2019 Financial Assurance Estimate Form  
(with pre-plat construction)

PROJECT INFORMATION			
The Trails at Aspen Ridge Filing No. 2	11/6/2019	\$ 389,310.00	PUDSP-191
Project Name	Date		PCD File No.

Know what's below.
Call before you dig.

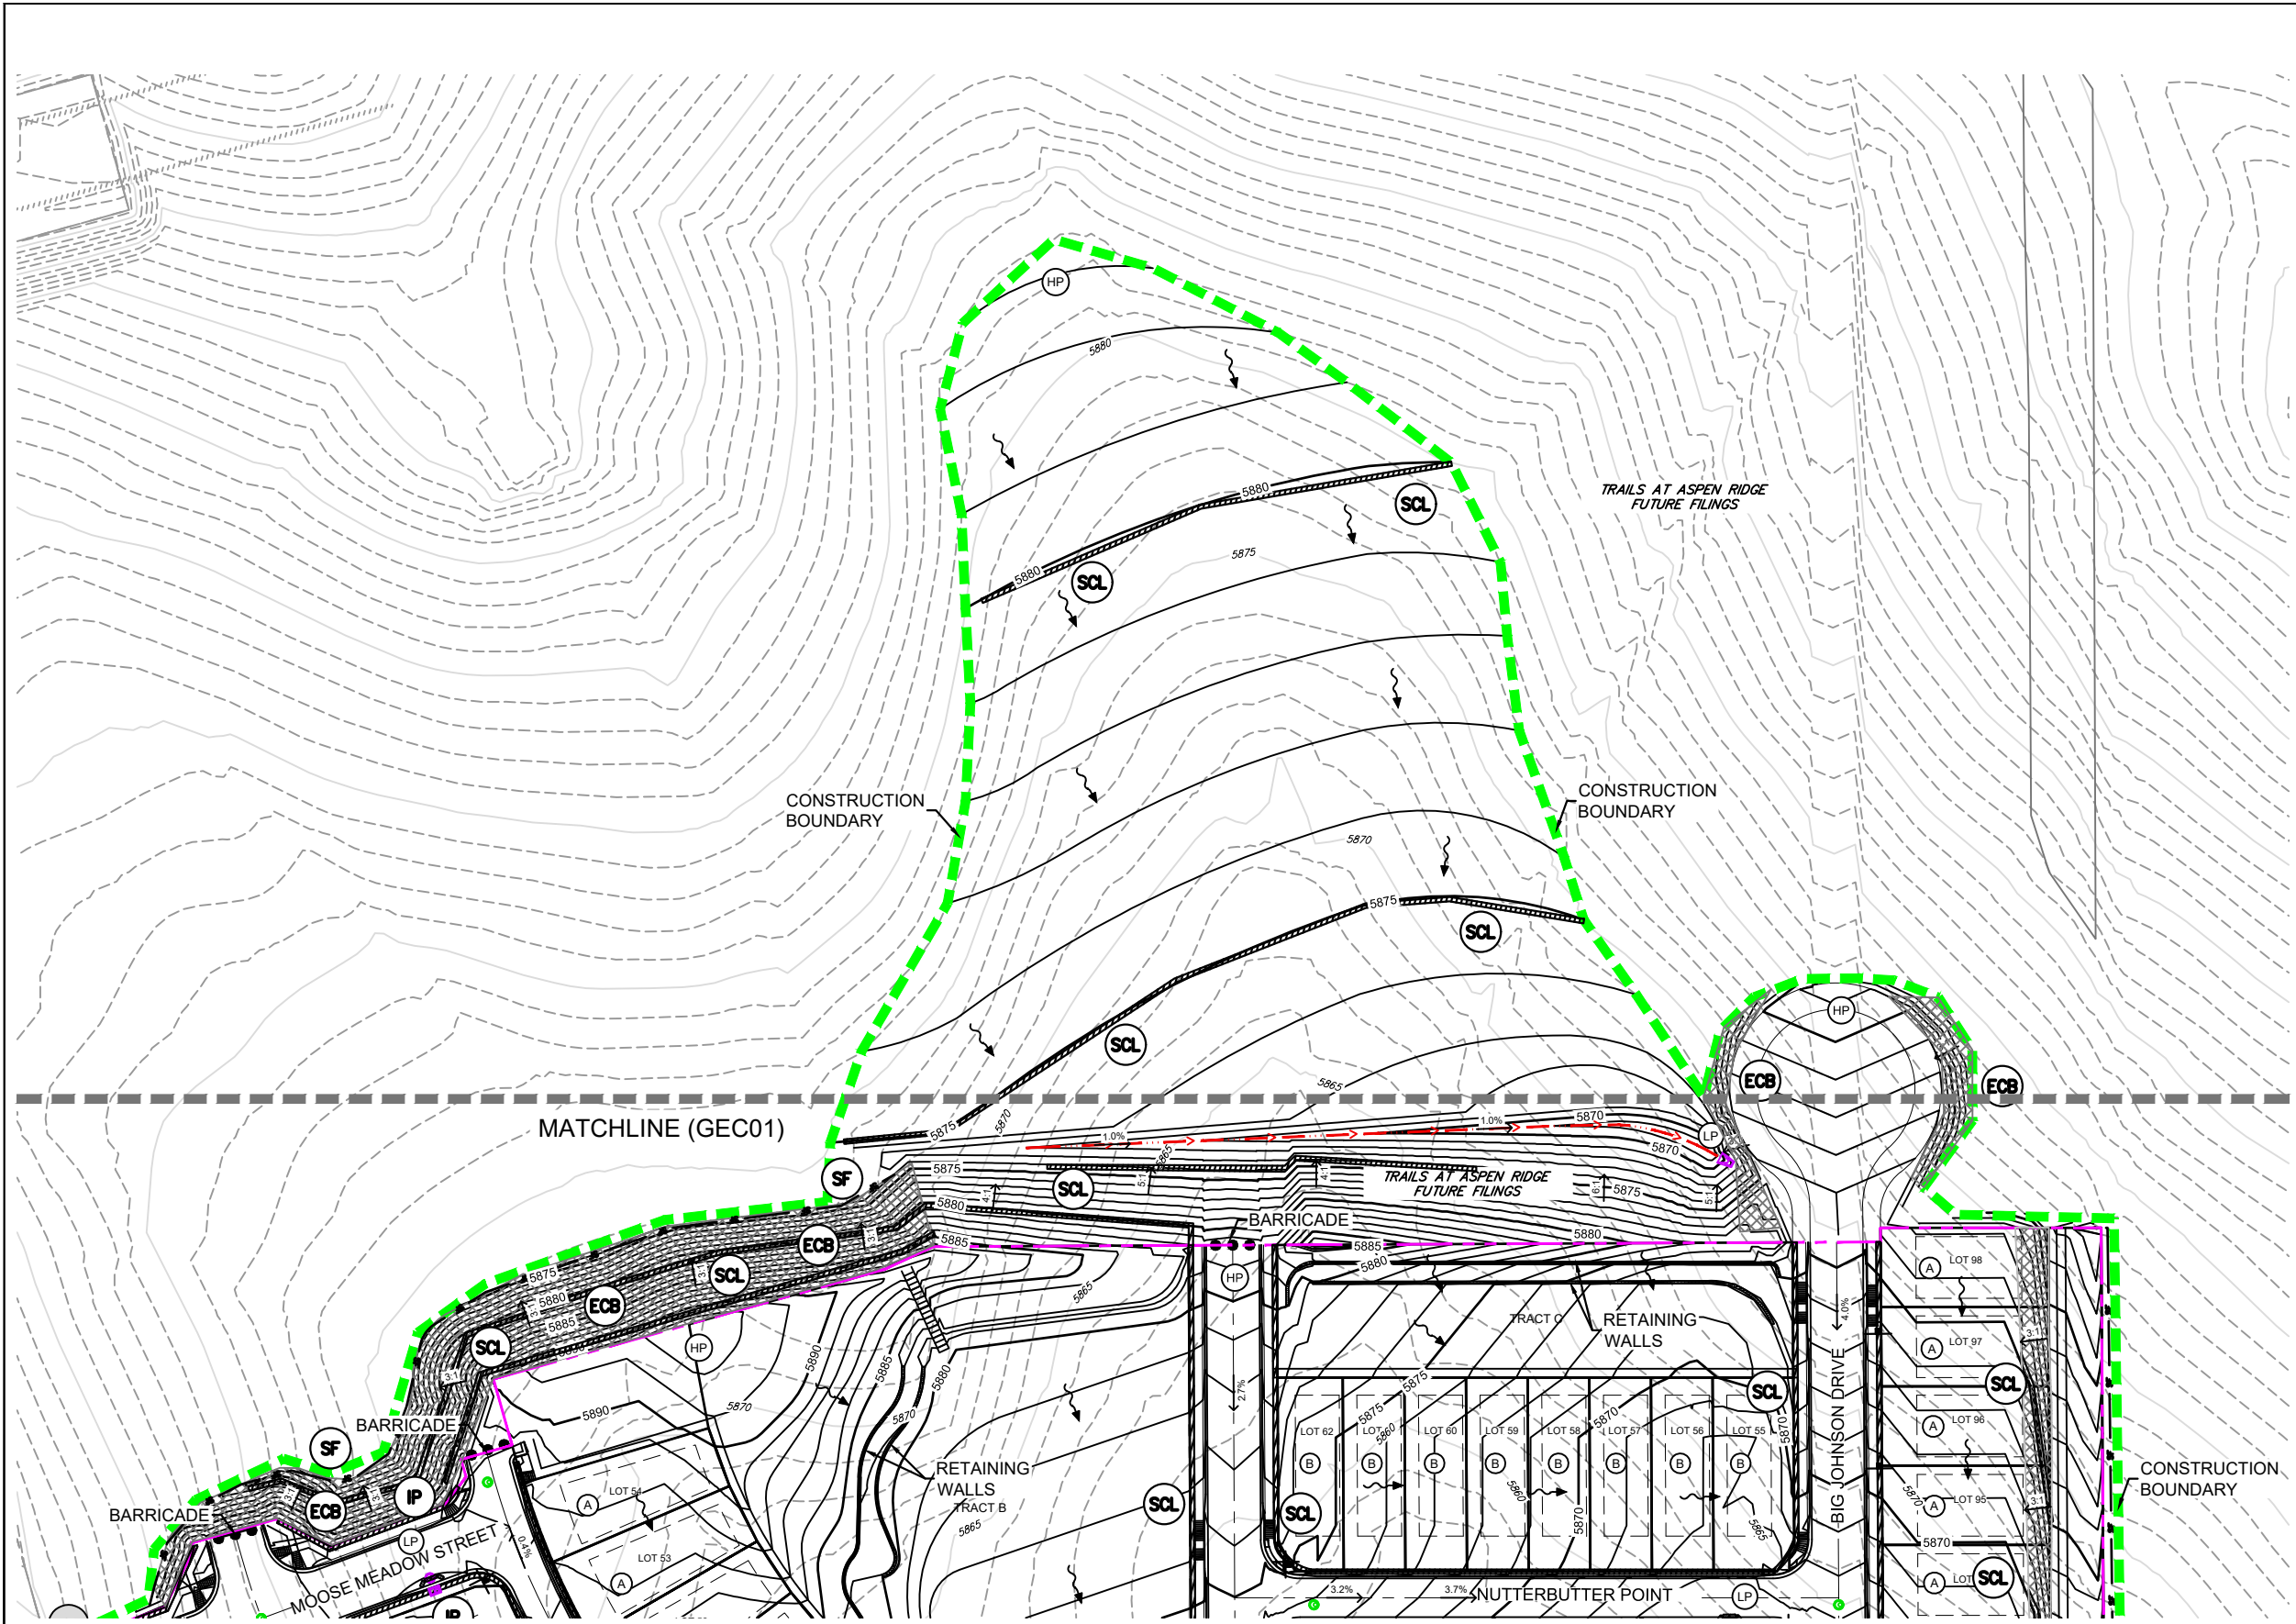
update the items and quantities accordingly per comments on the GEC plan.

There are 13 inlet protections shown on the GEC plan. Please revise.
